**From:** James Russell  
**Sent:** 24 May 2013 16:56  
**To:** Stephen Kilmartin  
**Subject:** Pendle Garage Site, Clitheroe Road, Barrow - Ref: 3/2013/0169P

I have considered the Environmental and Intrusive Noise study dated 28 October 2012 in relation to construction of 20 new build semi detached properties;

Figure 3: Glazing and trickle vent zones

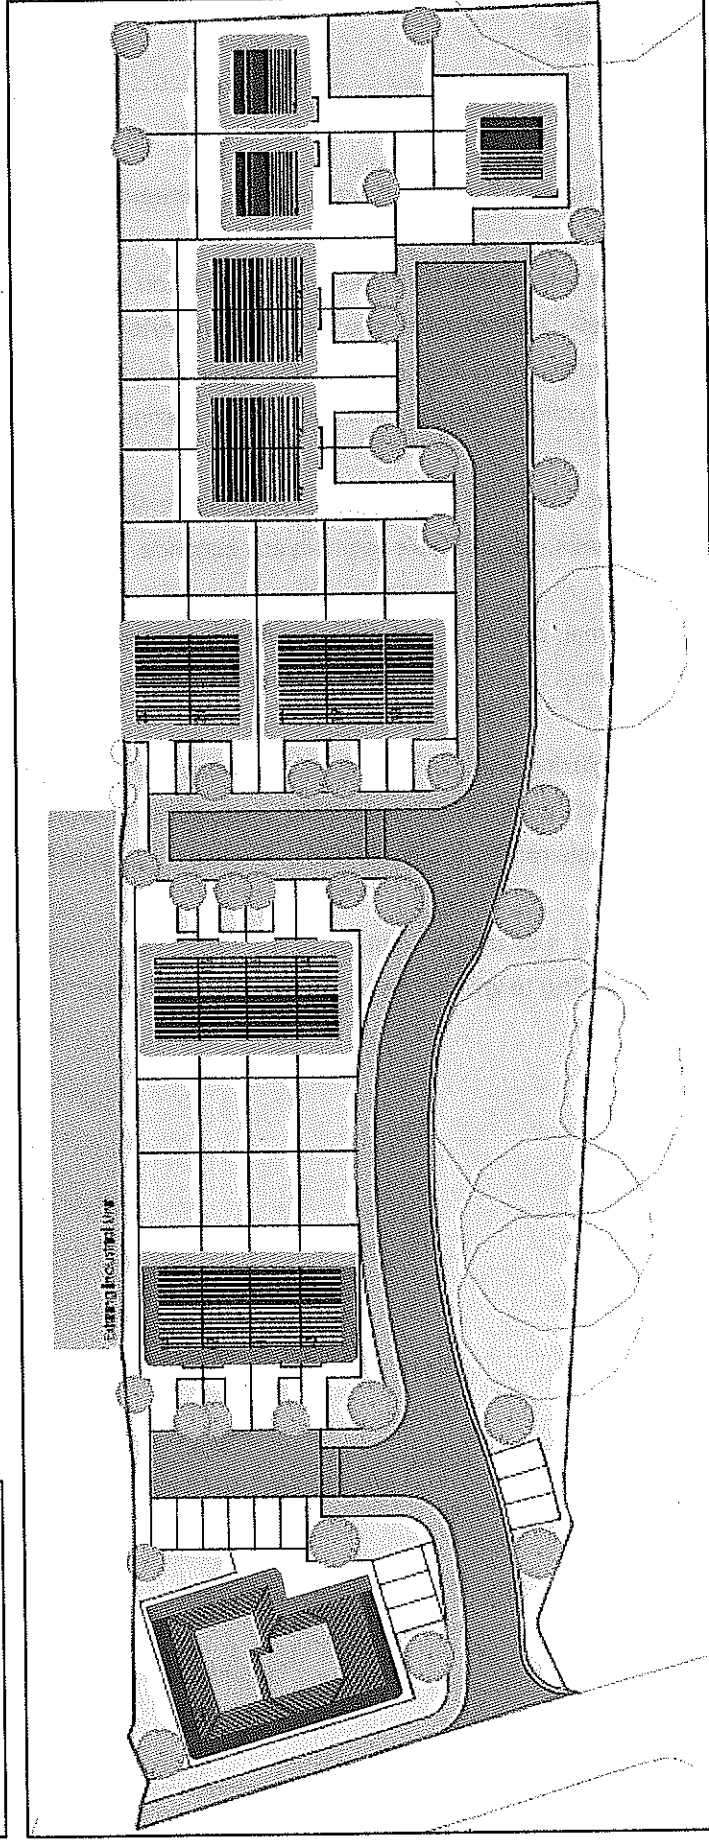
- Applying a precautionary principle, I would recommend that all properties be required to achieve WHO 30 dB(A) 'good' noise standard in living and bedrooms - by use of 10/12/6 mm glazing units with all being fitted with acoustic trickle vents Type 2

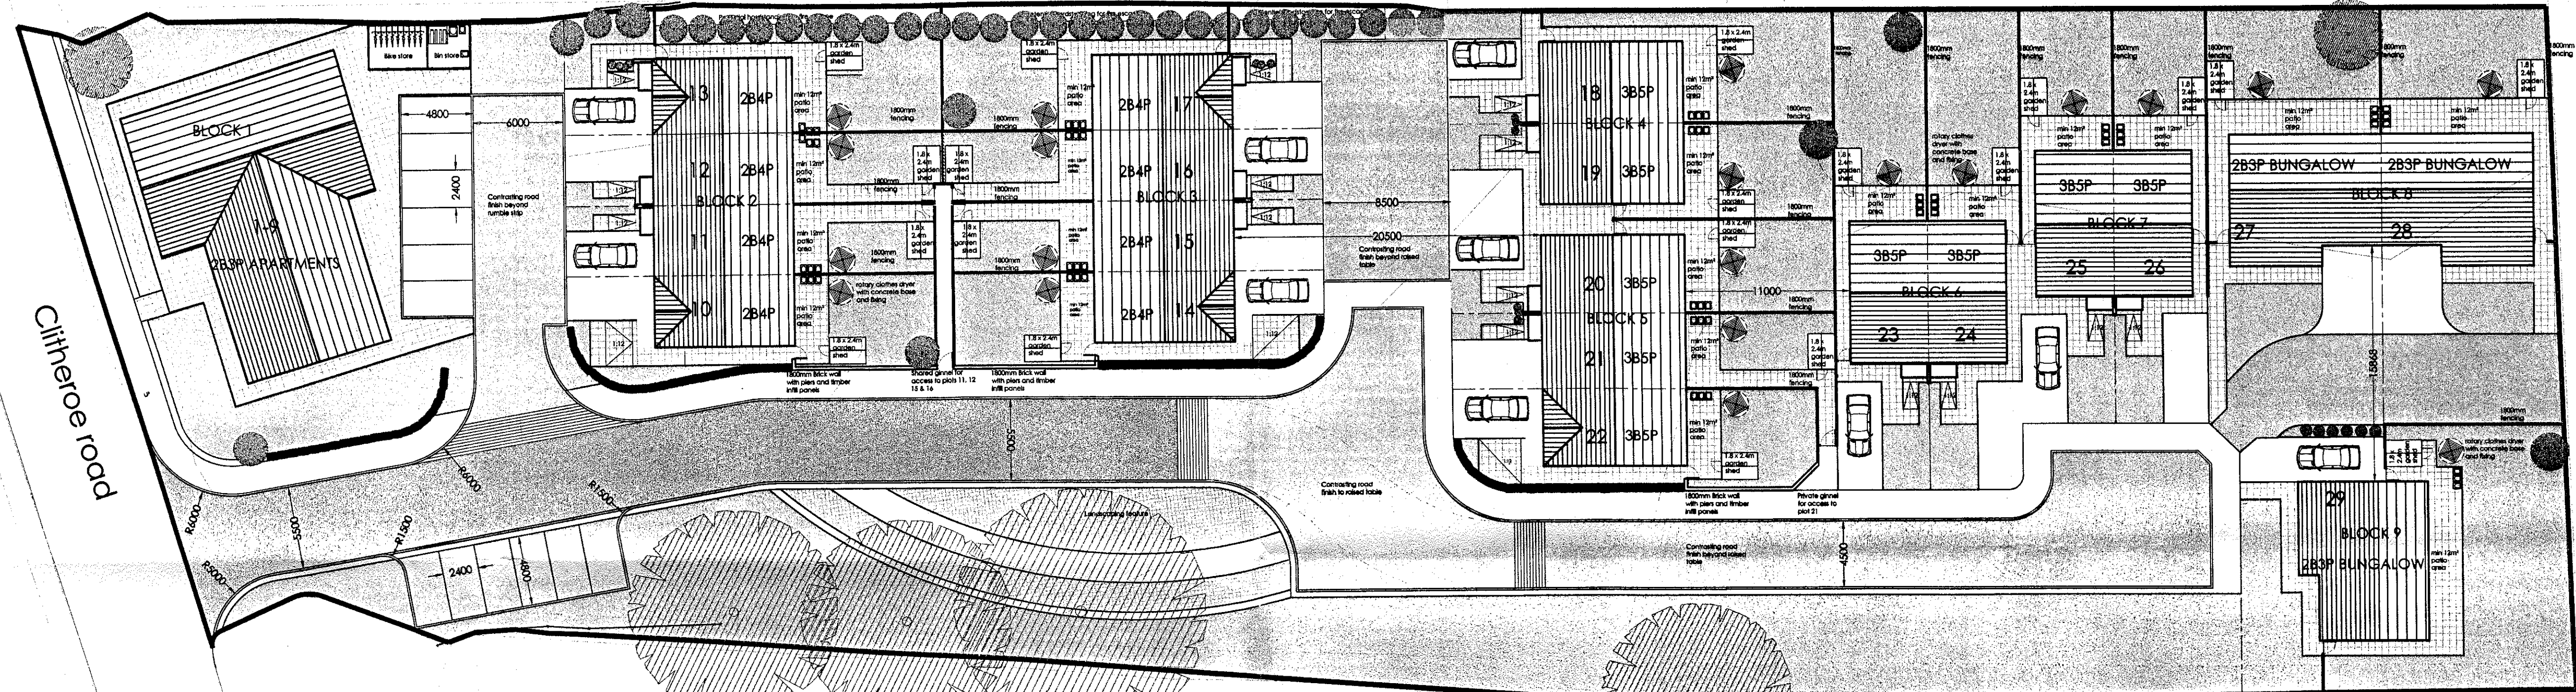
- Under the circumstances I would support your preference for a reversed layout on site with the access road being between housing and the adj Industrial Units
